Our Ref: LU/74/22/DOC

Town & Country Planning Act 1990 (as amended)
Town and Country Planning (Development Management Procedure) (England) Order 2015
Approval of details reserved by condition imposed under ref LU/302/21/HH relating to Condition No 3 -
details of 3 No. rooflights.
2 Purbeck Place Littlehampton BN17 5DP

Arun District Council have decided to **REFUSE details reserved by condition for the following reasons:**

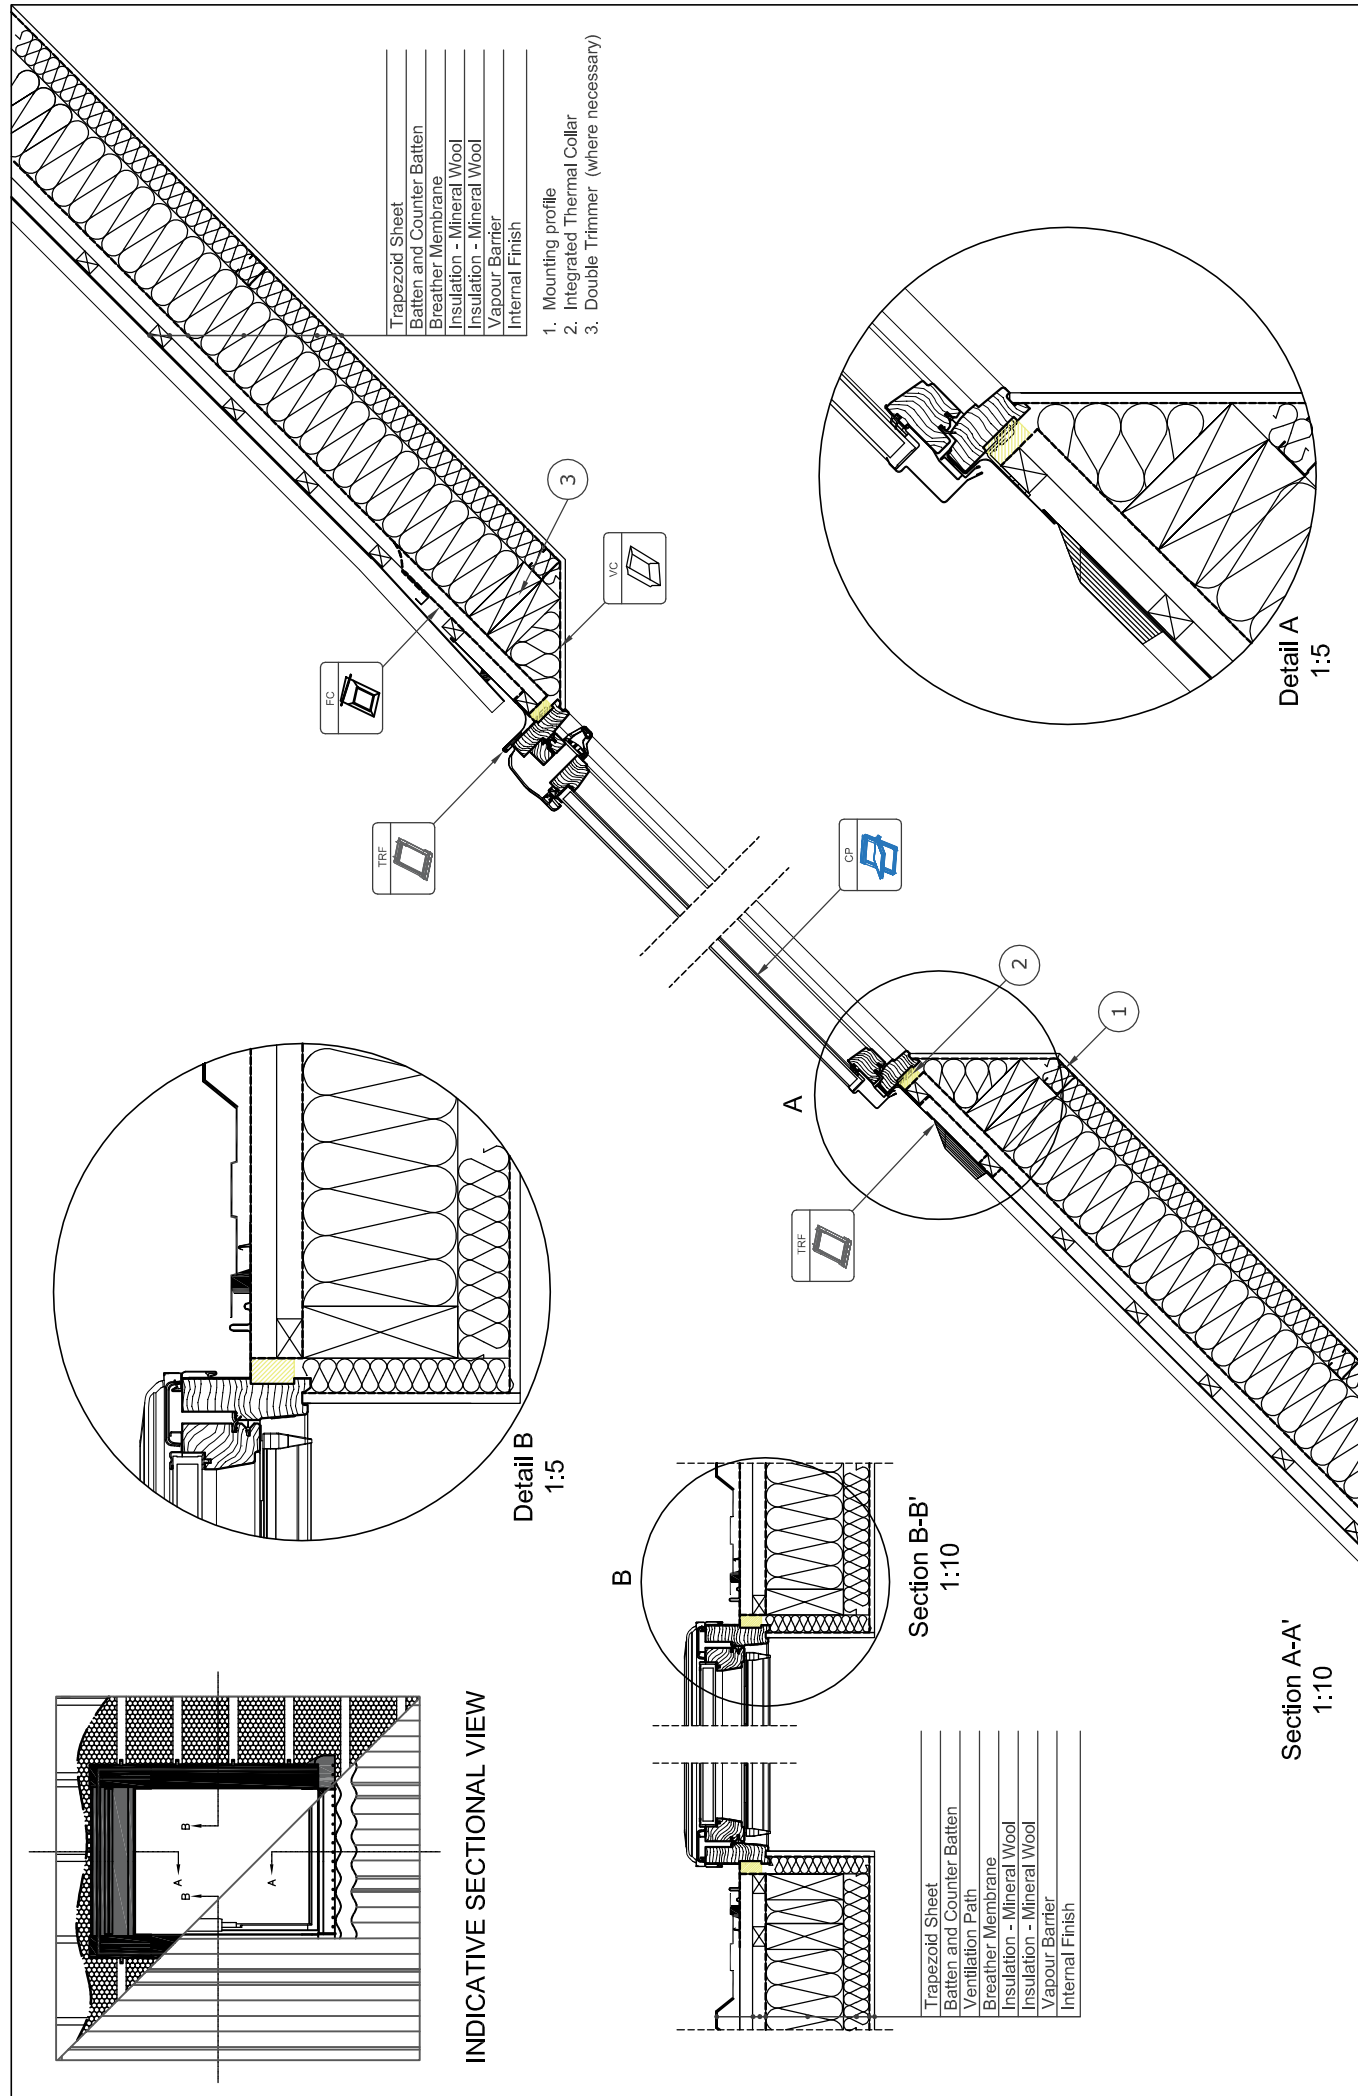
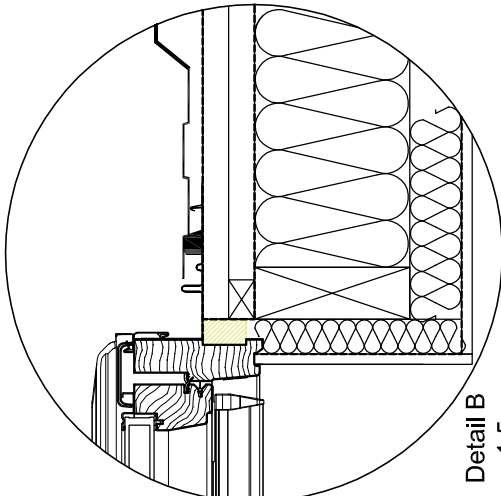
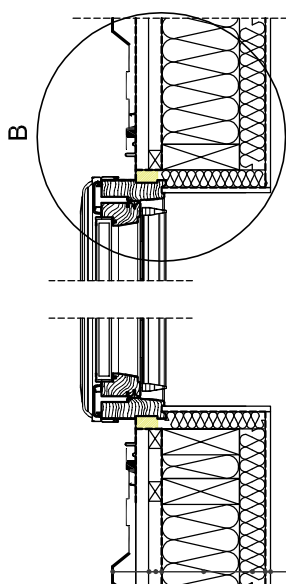
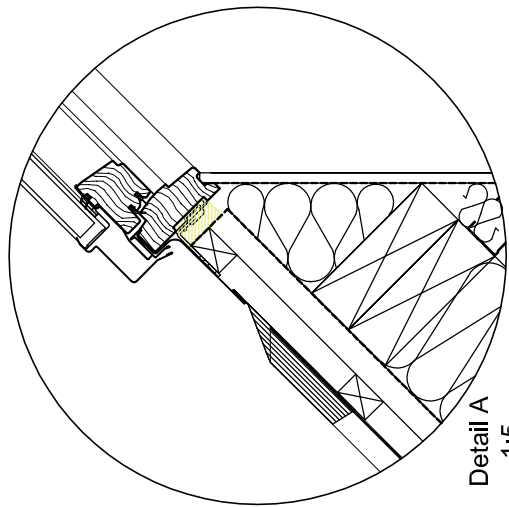
This condition cannot be discharged at this time as the details provided for the use of an externally applied glazing bar are unsuitable within the Conservation Area. Additionally, no details or specification for the proposed rooflight have been submitted in accordance with the condition.

Please resubmit with details of a conservation style rooflight, with appropriate glazing bar in accordance with condition 3 of LU/302/21/HH.
